Maritime &
Coastguard
Agency

Our ref: Thanet Extension Offshore
Windfarm Project (EN010084)

15 January 2019

Thanet Extension Offshore Windfarm Project (EN010084) Examination Authority Actions and Questions

Figure 3: PLA Simulator extent (ESL Pilot Launch tracks also shown - demonstrating area of activity for North East Spit Station).

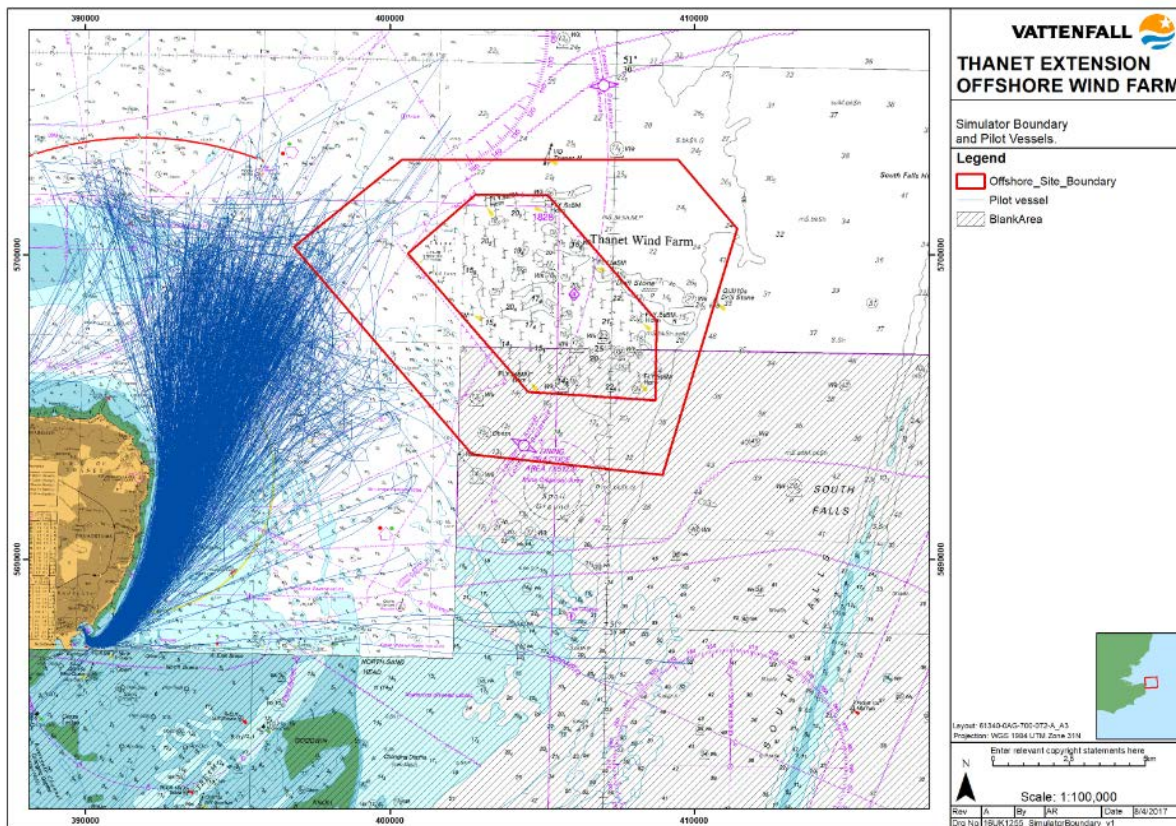
Please provide your assessment of the degree to which the Pilot Transfer Bridge Simulation Report [APP-090] can be relied upon or ascribed weight by the ExA. If you conclude that it is of limited reliability, please record your reasons for reaching this conclusion

The MCA believes that, as the simulation utilised experience pilots in familiar waters, the results are likely to under-represent the possibility of unfamiliar overseas masters onboard ships. This has to be taken into account when assessing the reliability of the simulation study, and whether it reflects a true picture of the potential scenarios.

In addition, the analysis detected several examples where the remaining sea room would not be sufficient. The report states the alternative would be to relocate the North East Spit station, but this option has been removed from the NRA because it has significant implications on time, distance, rostering and working hours etc.

Sea Zones Plan – Reduction in red line boundary

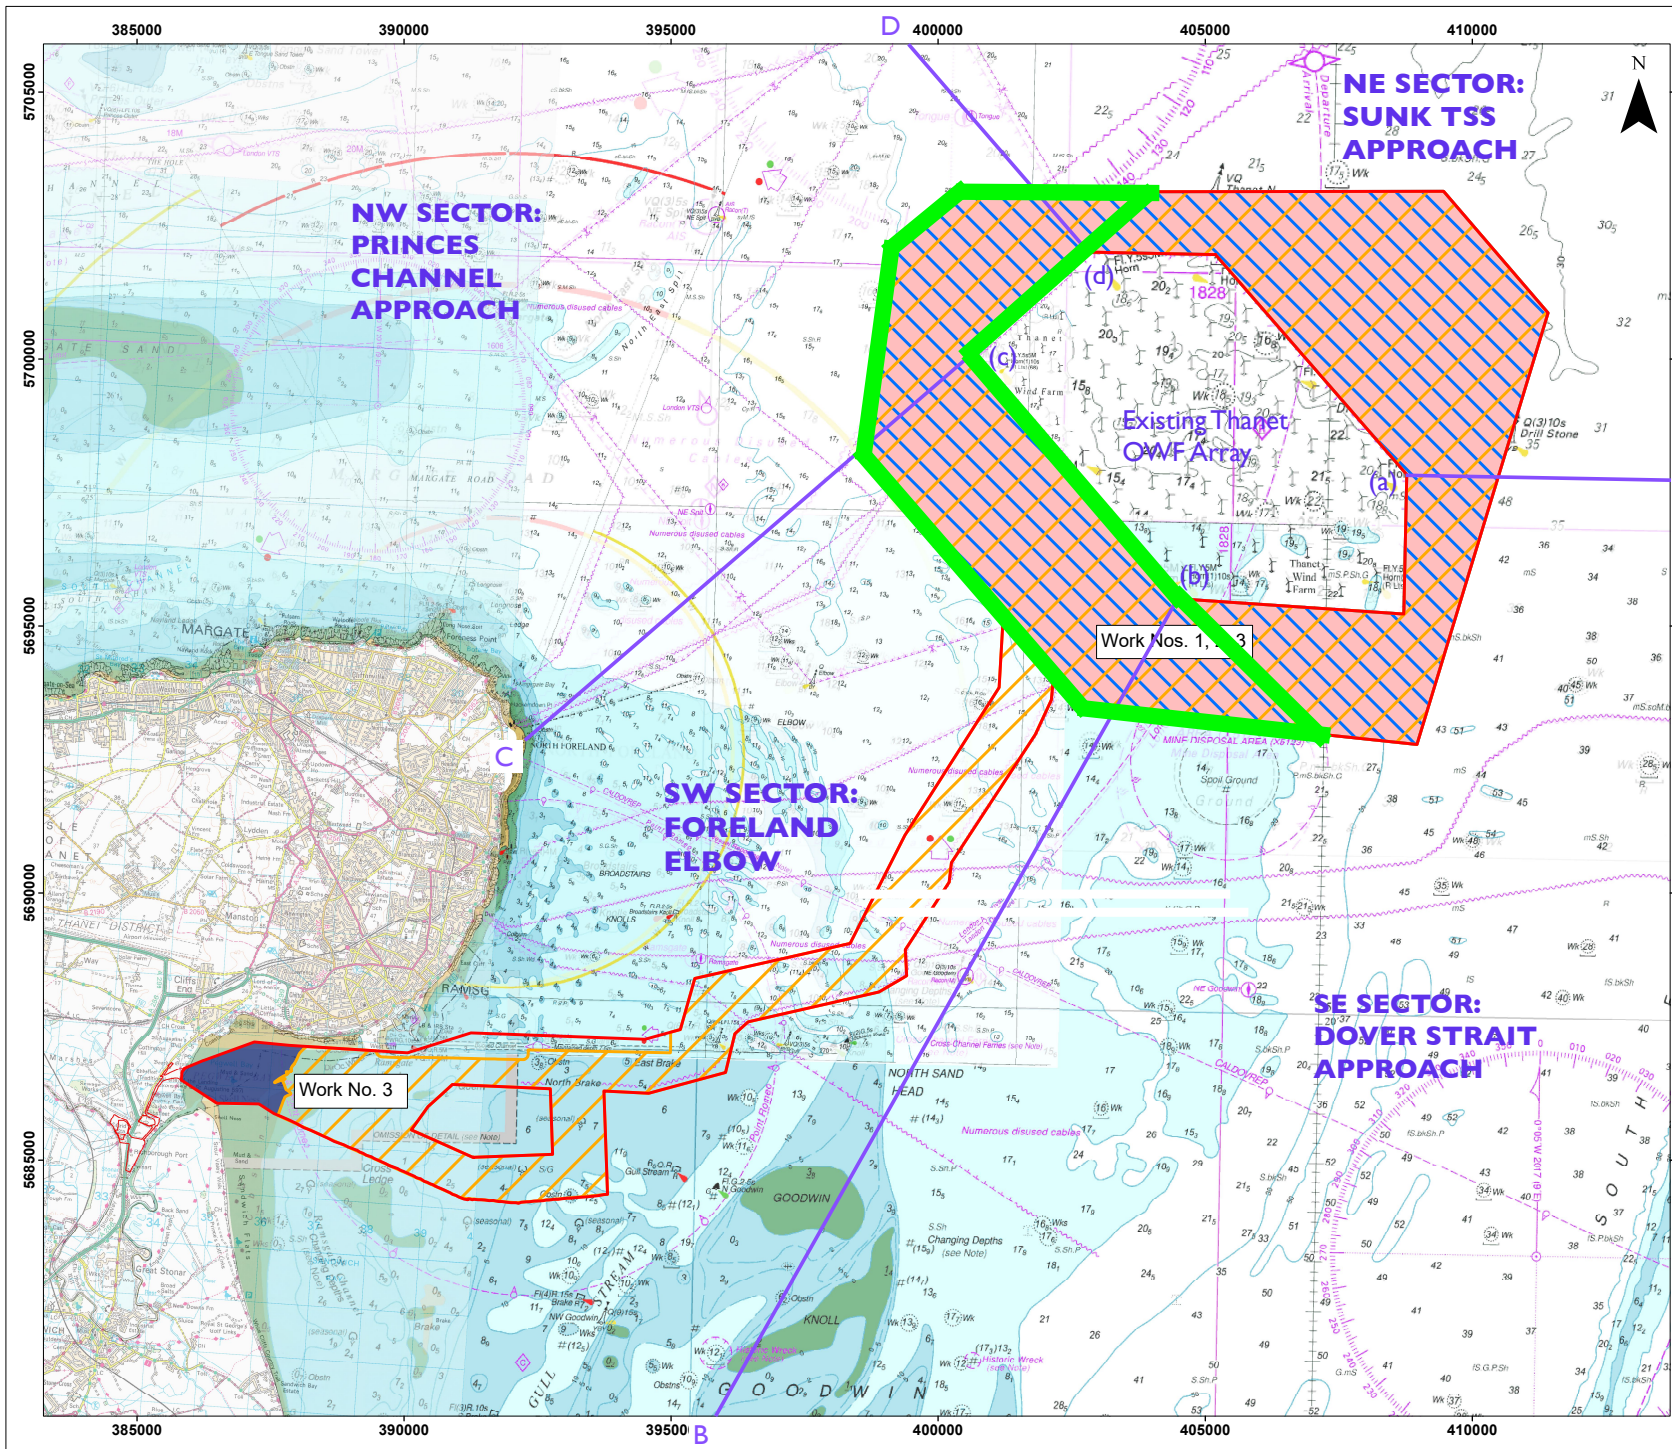
Action 7: *Red Line Boundary (RLB)* *All hearing participants requesting a reduction to the Red Line Boundary (RLB) . Where proposals to reduce the extent of proposed array area within the Thanet OWFE RLB were made at ISH2, parties making such requests are asked to provide:*

- *A plan based on the Sea Zones Plan [OD-008] identifying the extent of the proposed reduction*
- *A written justification, explaining and evidencing the need for the extent of the proposed reduction.*

See attached image.

There is a clear increase in risk with a significant reduction of available sea room on the western extent, in an already highly complex area for navigation. This means; a) the frequency of encounters increases, b) small vessels are closer to bigger vessels, and there is a reduced margin of error for pilot boarding arrangements. Whilst it is understood that the NRA mentions only a limited impact to traffic routing, it is evident that the traffic passing between the windfarm and the Kent coast will be squeezed further to the west.

The MCA has considered the increase in risk and does not find the increase acceptable, considering the qualitative assessment made by a range of master mariners and industry experts regarding real life examples of seafarer behaviour, in addition to the quantitative assessment made in the applicant's Navigation Risk Assessment. We believe that quantitative assessment of risks is unlikely to capture the true implication of risks posed by converging volume of diverse traffic, particularly during adverse weather conditions and poor visibility.
